From: Cllr. Gill Yeates
To: Victoria O'Toole
Cc: Cllr. Martin Lury; Cllr. Kerton Batley
Subject: Re: MBNL_ARN005 - ROWAN WAY SW (2/3/4/5G proposed mast)
Date: 01 June 2020 15:22:16

From: Victoria O'Toole [redacted]
Sent: Monday, June 1, 2020 12:51:46 PM
To: Cllr. Gill Yeates [redacted]
Subject: MBNL_ARN005 - ROWAN WAY SW

Please find attached consultation information regarding a proposed upgrade to the existing telecommunications installation at the above site for your information/comment.

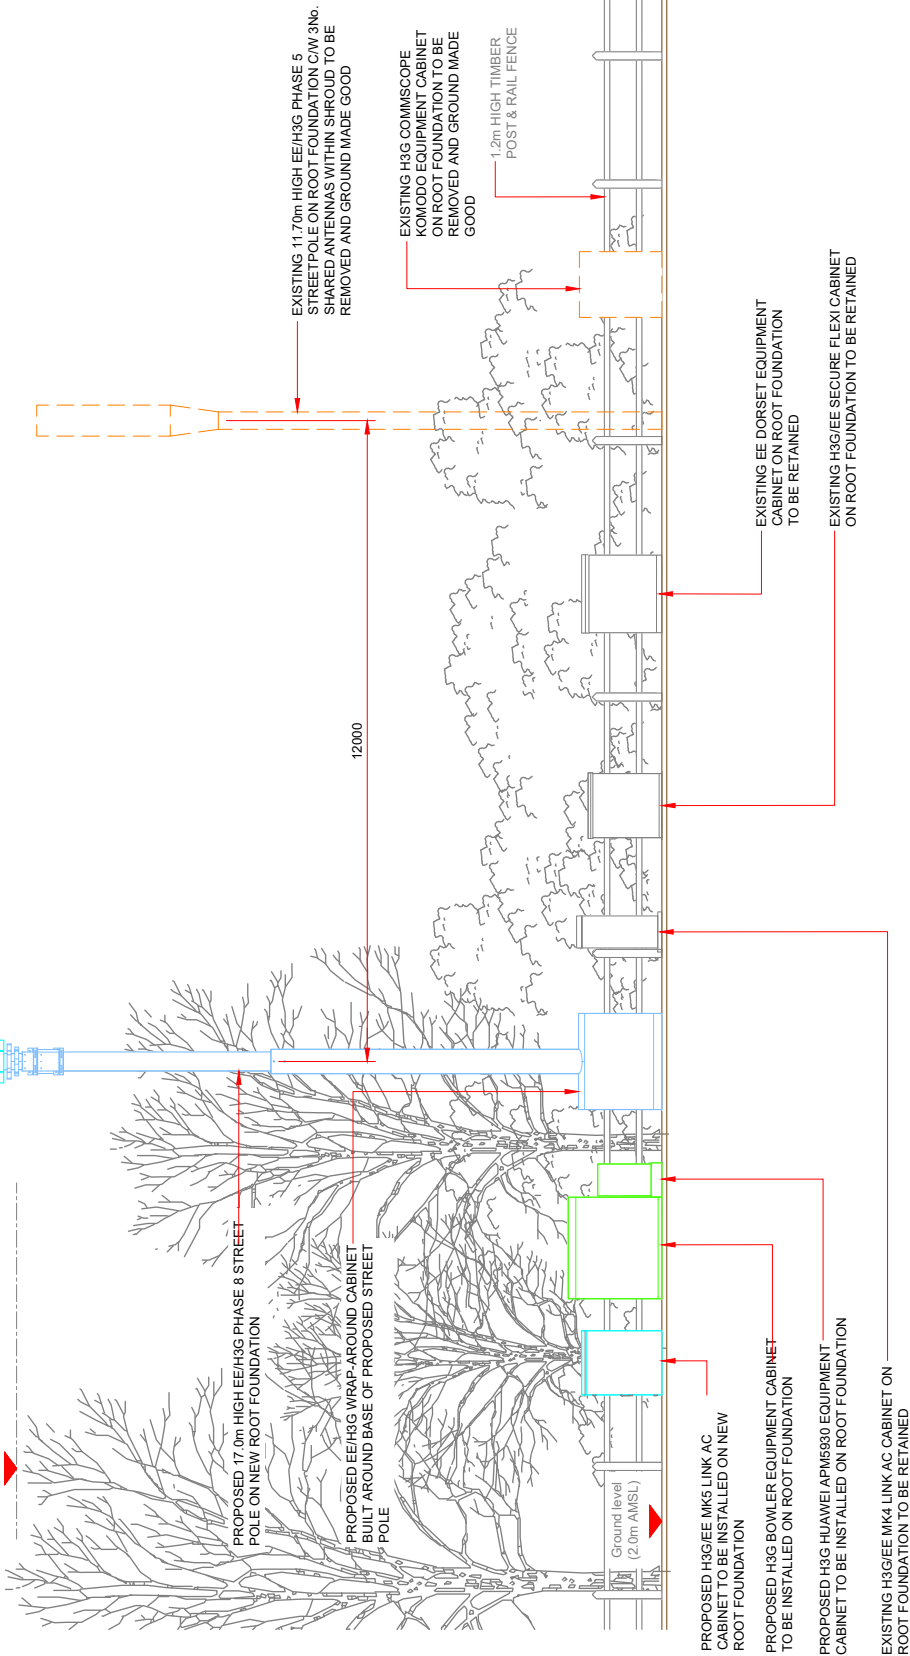
Also, is 20m the standard height for an antenna? Seems rather high to me. I only mention this because of the glider club operating nearby and I wonder if this might have an impact on them.
